August 12, 2014

Harnett County Government Complex  
307 W. Cornelius Harnett Boulevard  
Lillington, NC 27546

**Re: Status of Improvement Permits - Trotter's Ridge**  
**Applications #14-5-34119 - Lt 32 & #14-5-34140 - Lt 32-A**

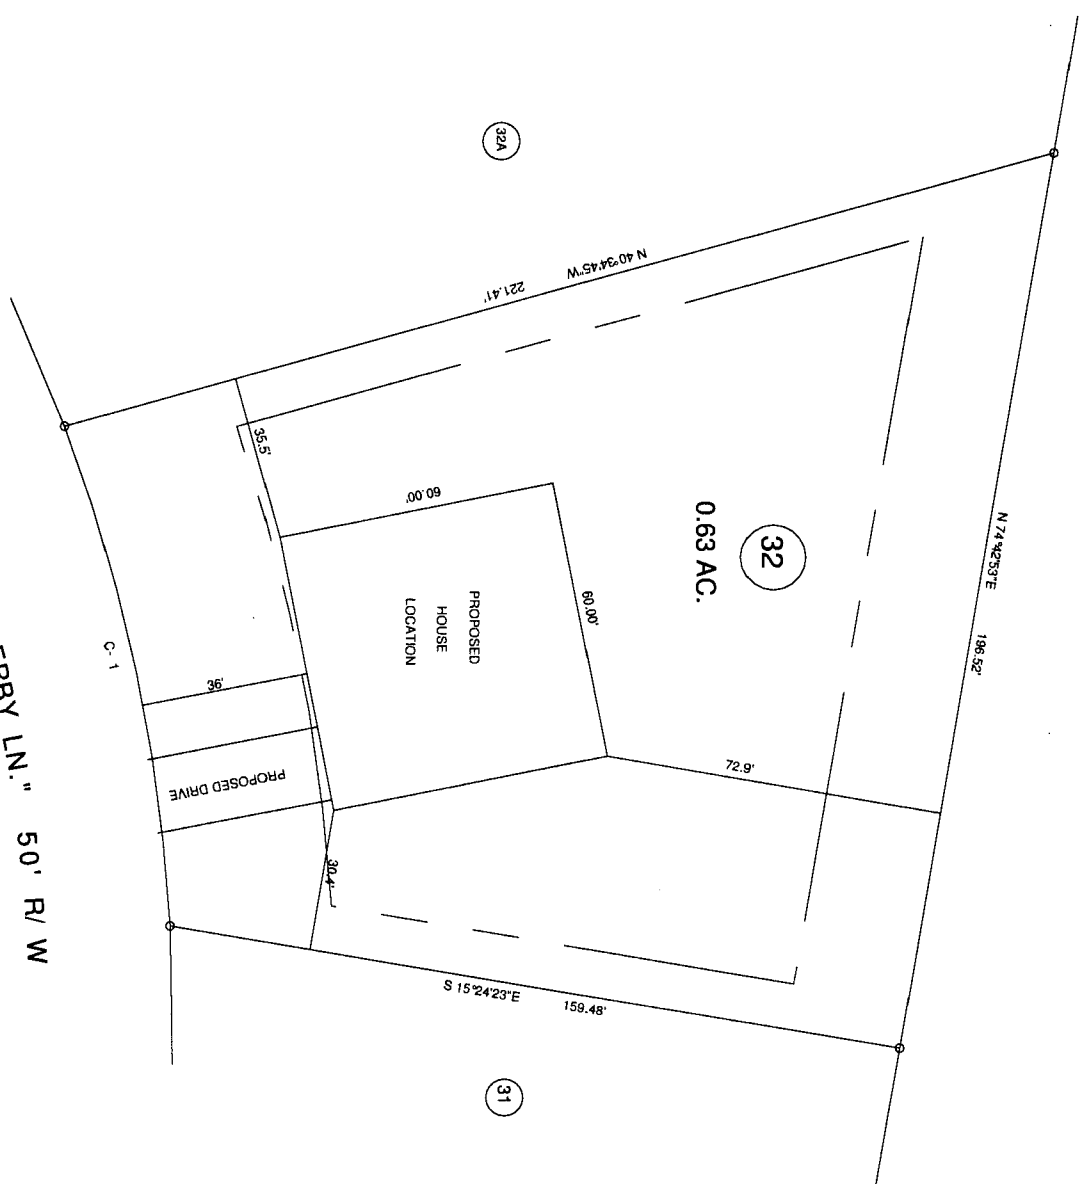
- 1. Use pink flags to mark property lines and irons that are set by surveyor need to be visible *(\$25.00 fee incurred)*
- 2. Use orange flags to mark house corners *(\$25.00 fee incurred)*
- 3. Directions not clear to property *(\$25.00 fee incurred)*
- 4. Lt. 32-A needs only brush or vegetation removed
- 5. Driveway not shown on site plan
- 6. Lt. 32 Requires backhoe pits
- 7. Other
